STAFF REPORT BIG CREEK TRAILS REZONE (RZ-15-00001)

TO: Kittitas County Board of County Commissioners
FROM: Kittitas County Community Development Services
RE: Big Creek Trails (RZ-15-00001)
DATE: October 18, 2016

RZ-15-00001

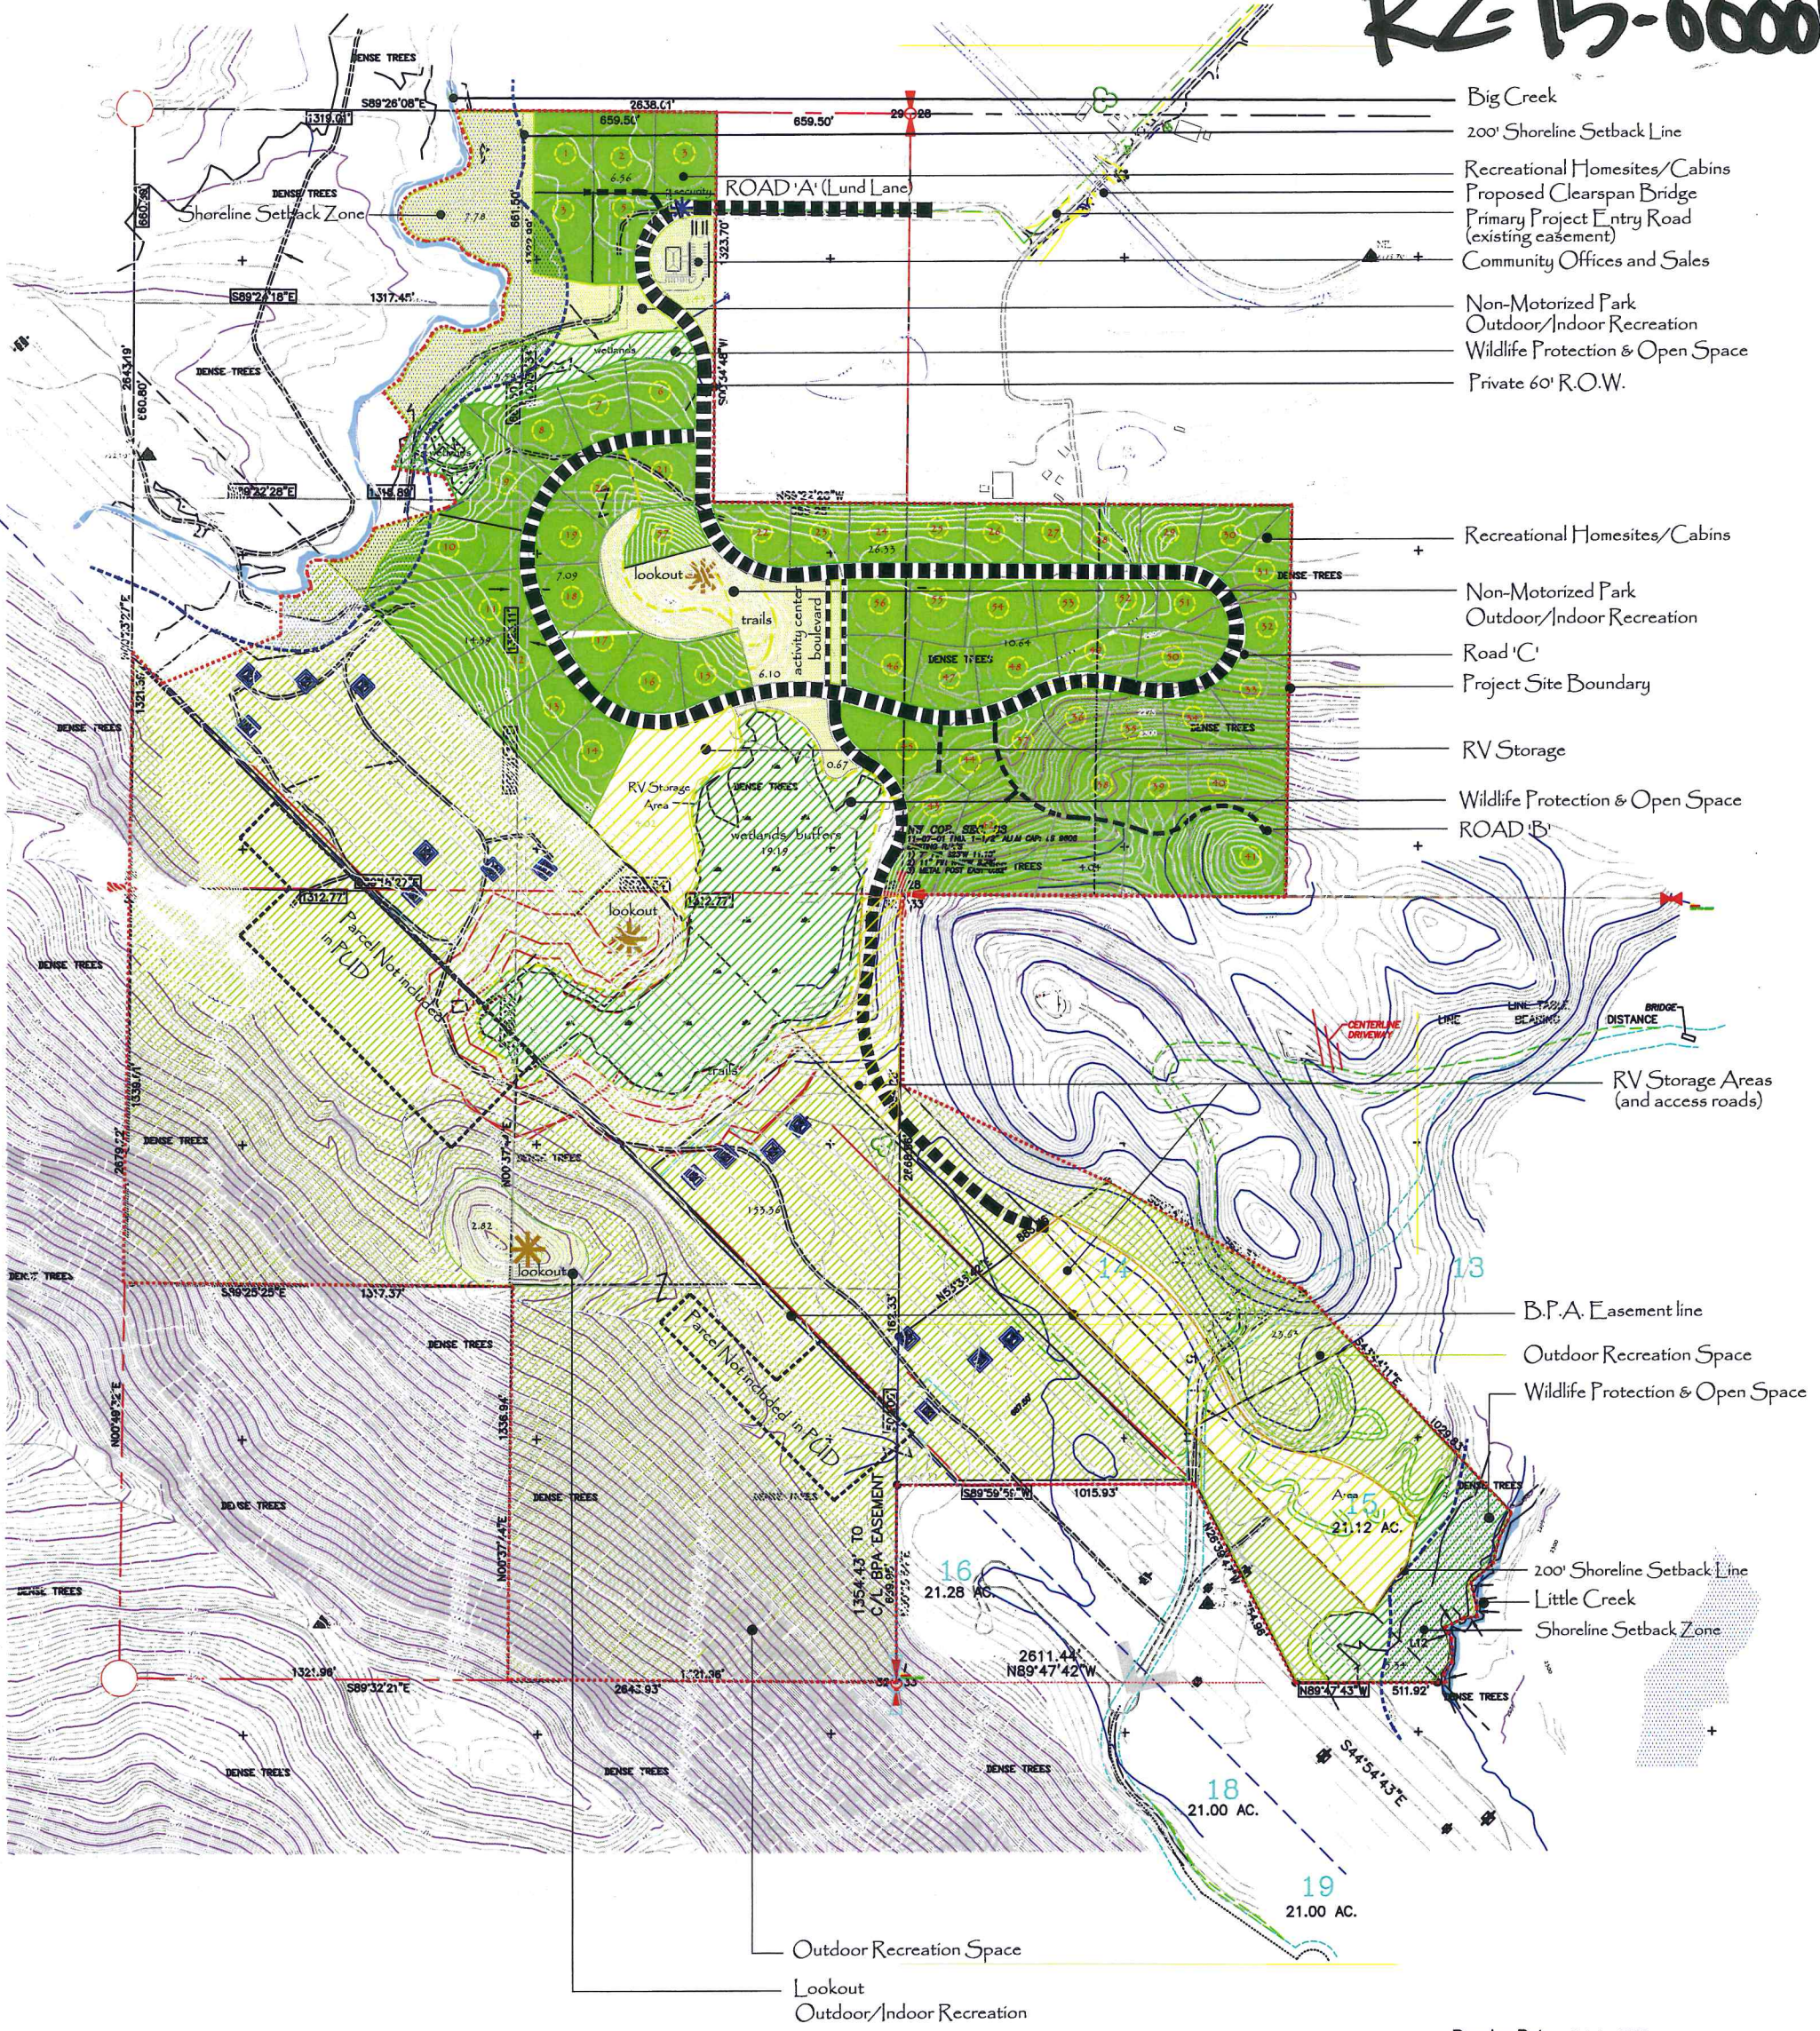
- j. The applicant shall relocate lots 57 and 58 to an area adjacent to or in close proximity to the larger residential area identified on the site plan that has been submitted with the PUD application as conditioned as follows:

- 1) The current planned residential foot print, identified on the site plan that has been submitted with the PUD application, may be enlarged a maximum of 7.5 acres to absorb the relocation of Lots 57 and 58 (identified on the site plan attached to the PUD application);

- 2) The current design of the home sites that may be redesigned to absorb the relocation of these two home sites which may require further redesign of other components of the PUD layout;

- 3) The The road that was planned to connect the two home site foot print areas will not be required as the roads of the PUD will be built to the public road standards as defined in Kittitas County Code Title 12; and

- 4) The recreation storage area may be moved or split into two locations with one being located near or adjacent to the northern boundary of the BPA power line easement and not adjacent to the residential area.

RURAL AREA PUBLIC ROADWAY DESIGN STANDARDS

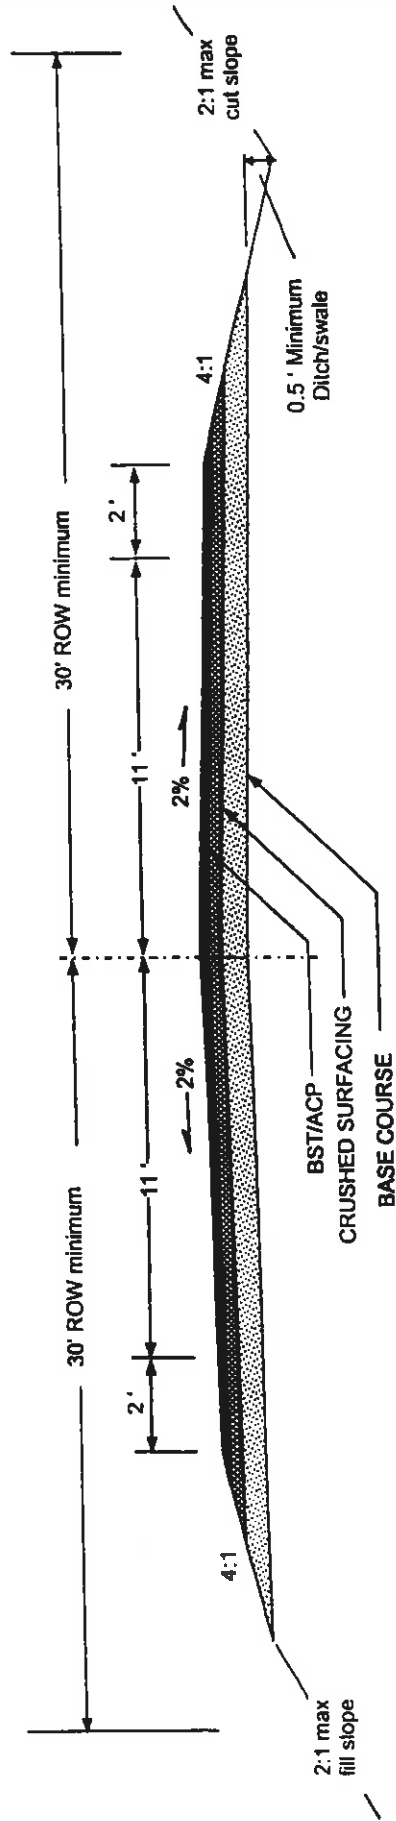
- b. The Lund Lane extension and the crossing of the irrigation canal will be built to meet public road standards.
- c. Construction of Road "A" will be built meeting public road standards and construction of Road "B" will be built to current private road standards with an all-weather surface.
